2023/0278

Retention of marquees and outdoor container bar in rear car park

The Crown and Anchor Inn, Barugh Lane, Barugh Green, Barnsley, S75 1LL

Figure 3: Scenario C equivalent sound level map - $L_{Aeq,1hour}$

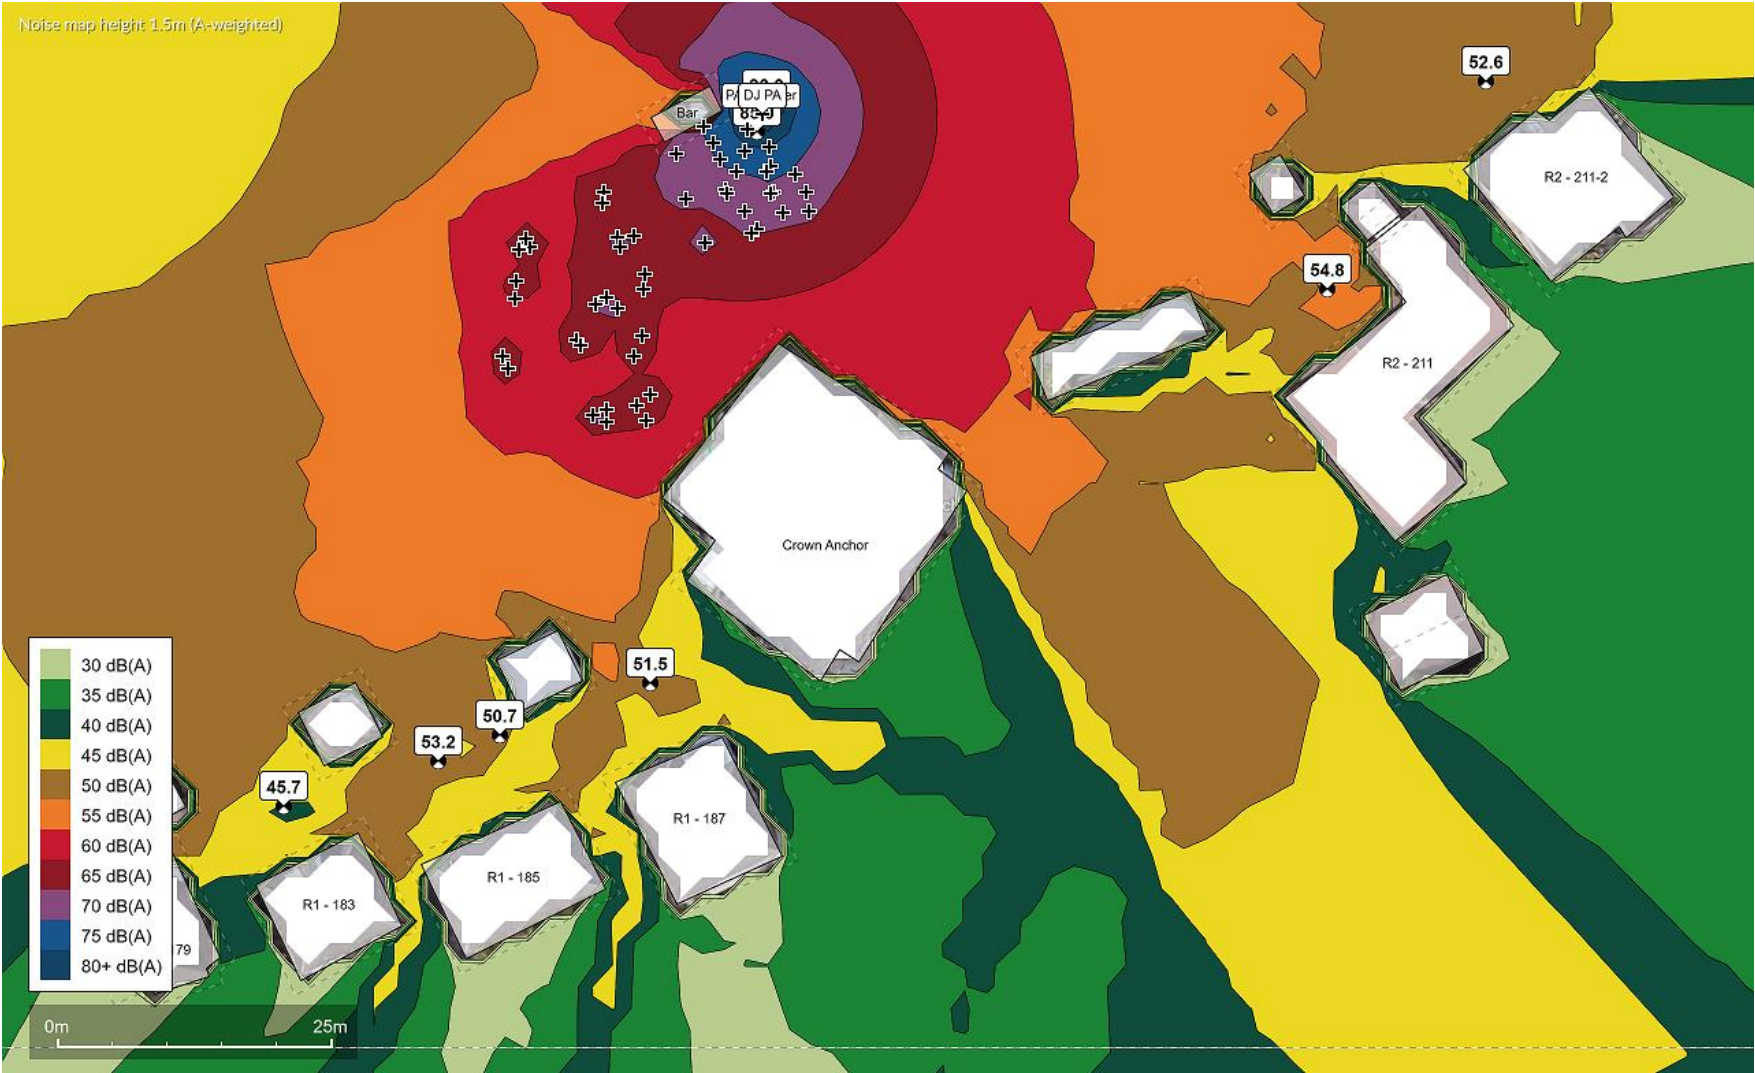
Pollution Control – Assessed the information in the Noise Impact Assessment (NIA) and questioned where the nearest noise sensitive receptors were located. The NIA presents 3 different scenarios of how the development may be used. "Scenario C" would not be an acceptable use as it is likely to have an adverse impact on nearby residents. Therefore, I would recommend a condition limiting the levels of amplified music. An agreed Noise Management Plan would also be required prior to use of the development. Upon receipt of the amended information, no objection was raised subject to conditions.

The NIA showed that scenario C resulted in an excessive nuisance to the nearest neighbouring receptor, which was acknowledged by the agent and should the application be approvable, a condition would be acceptable which restricted the use of the marquee to not be used for scenario C. Colleagues in Pollution Control assessed the amended NIA and did not object to the proposal subject to agent submitting a detailed noise management plan to support the development. Details of which would be submitted and agreed with the LPA prior to the use operating on site.

DRAWING No. 6135-403

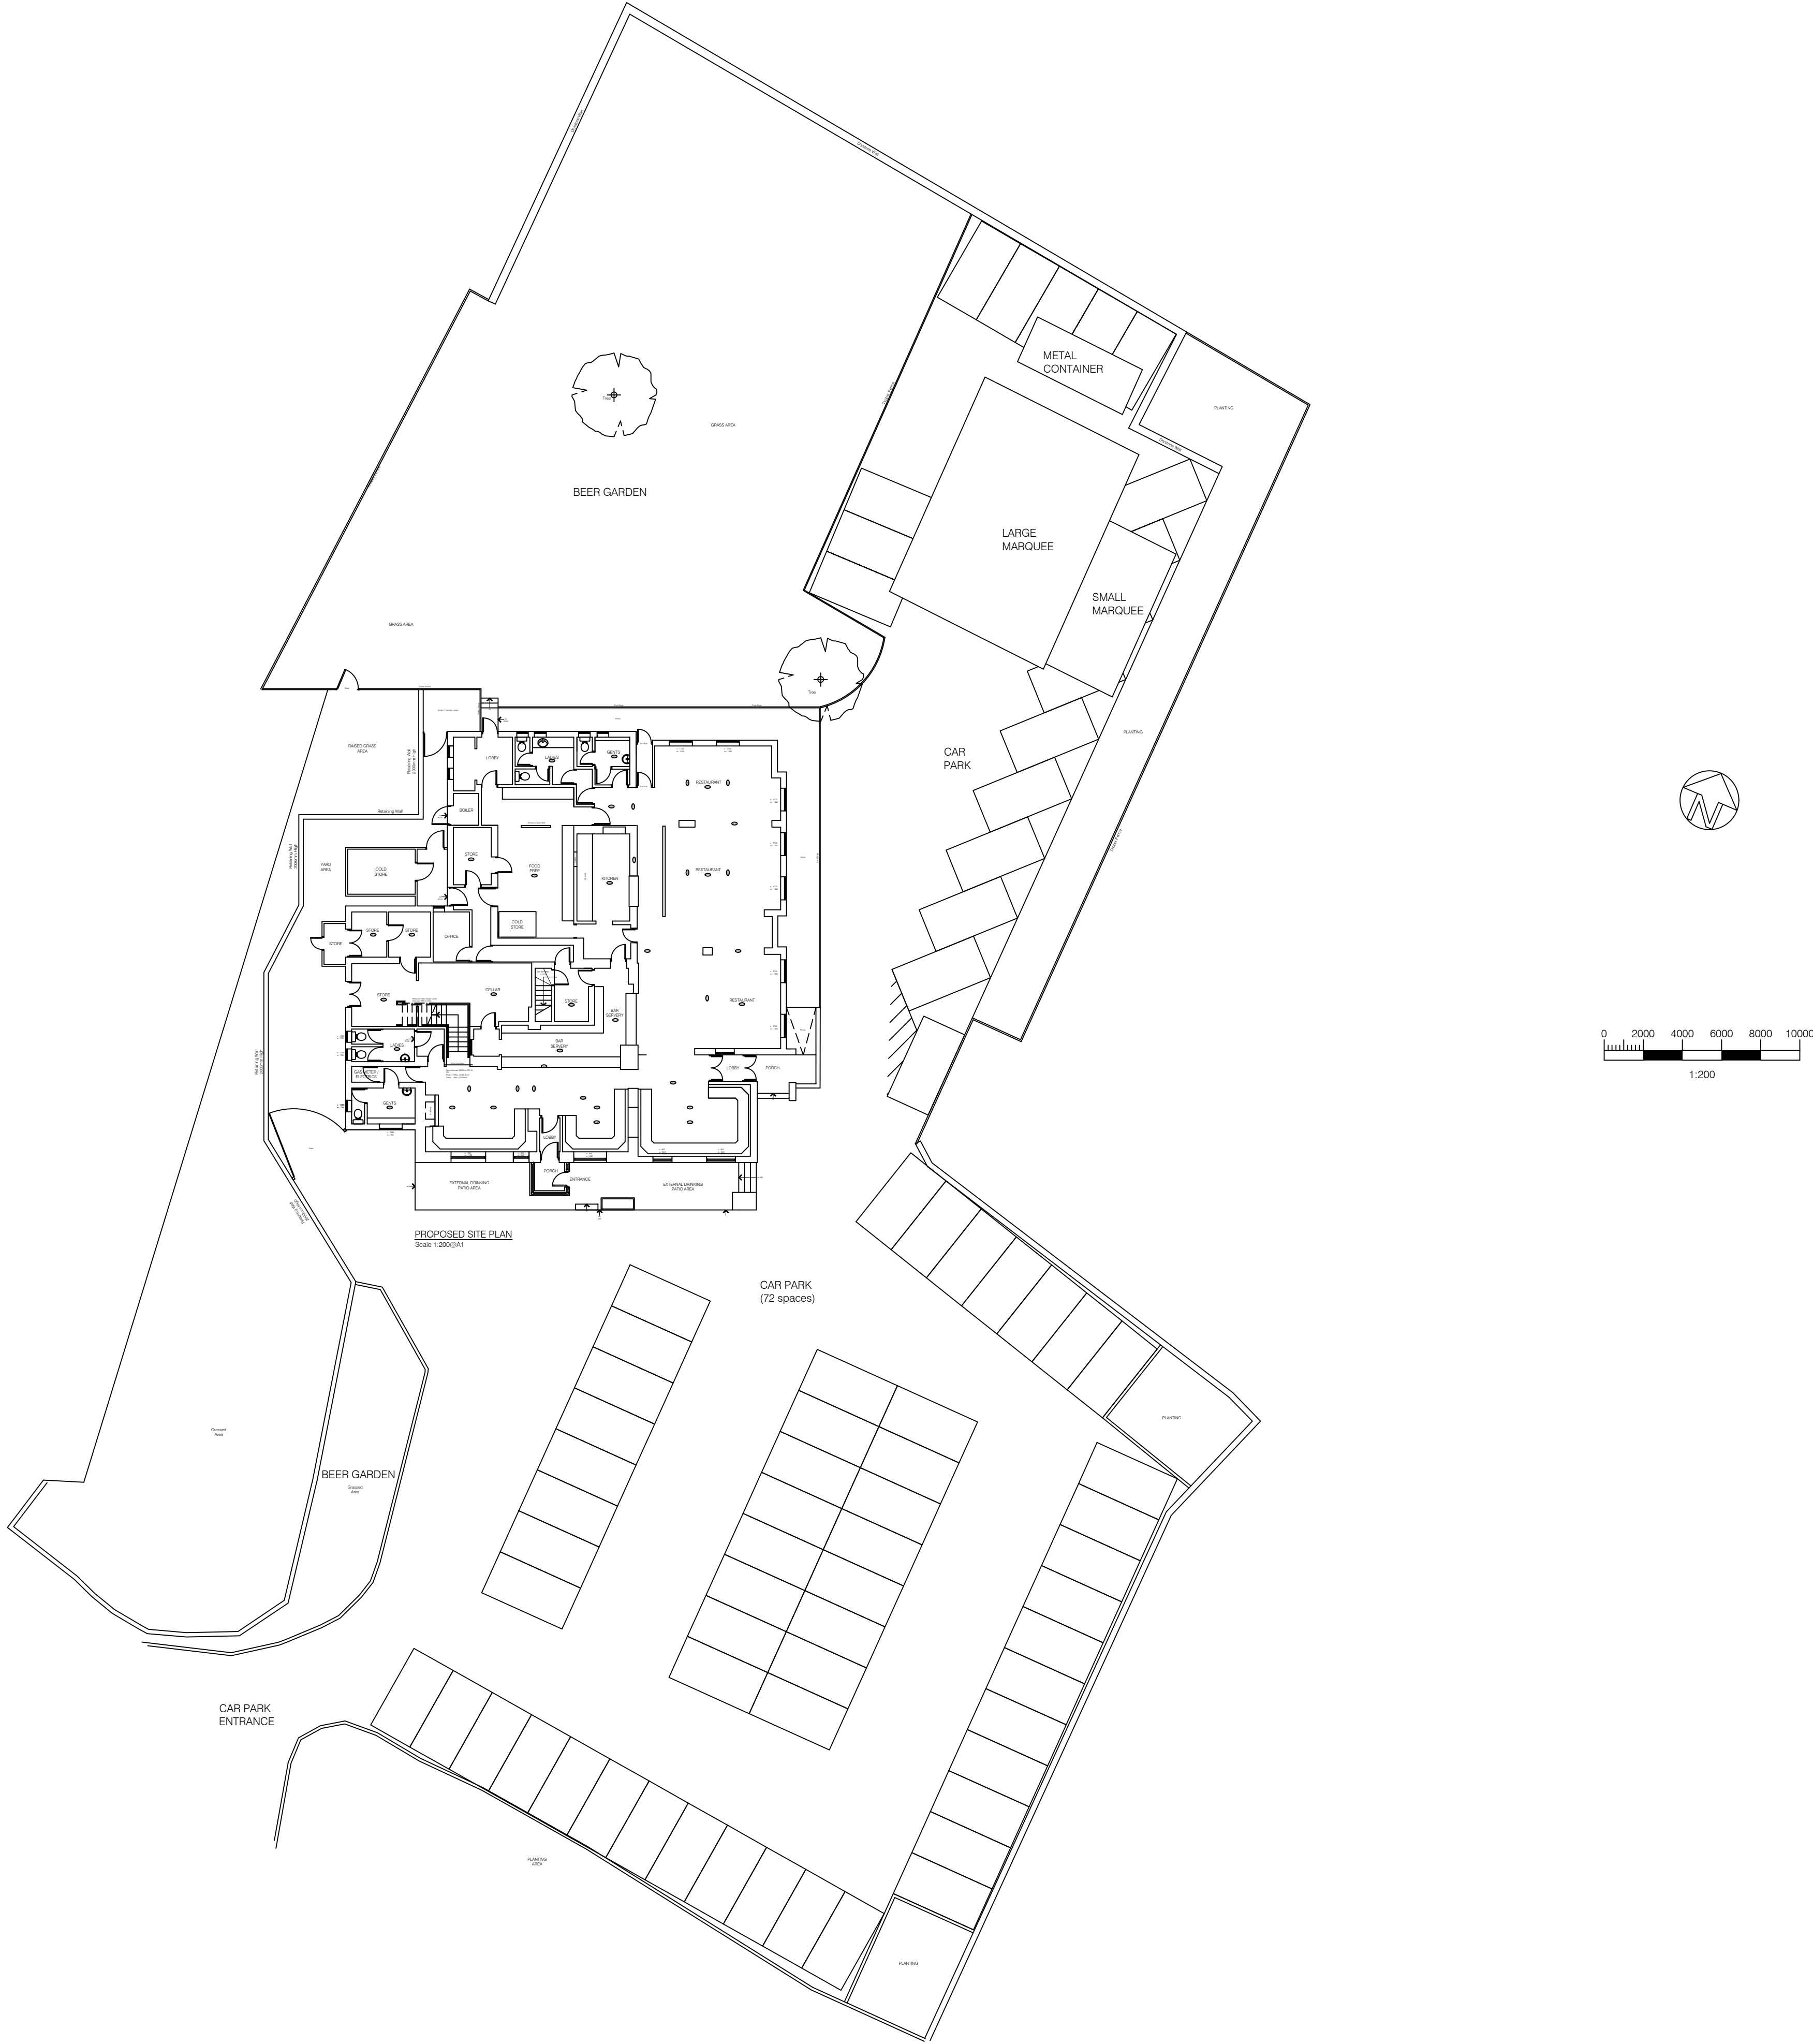
Second response - The additional information reveals that the maximum number of staff on duty at any one time is 12 which, in accordance with the Barnsley Supplementary Planning Document: Parking (2019), requires a total of 4 parking spaces for staff. The proposed site plan dwg. no. 6135-403A shows that these 4 spaces are to be provided within the site along with the 60 customer parking spaces. No alterations to the existing car park layout or surface treatment are required. The proposals are therefore considered acceptable from a highways development control perspective. No specific highways related conditions are deemed necessary.

The marquee (and retained smaller marquee) is situated on land that was formerly used as a car park. This placement resulted in a reduction of parking numbers on site from 74 to 62 (a loss of 12 spaces). Highways DC were consulted on the proposal and raised concerns over this loss and requested further information including an amended site plan showing the number and position of parking spaces on site, alongside employee numbers and staff parking. Colleagues in Highways DC did not raise an objection to the amended information after assessing against the Council's Parking SPD which requires 4 parking spaces for the outlined maximum number of staff on duty at any one time (x 12). The proposed development is considered to be acceptable from a highways perspective.
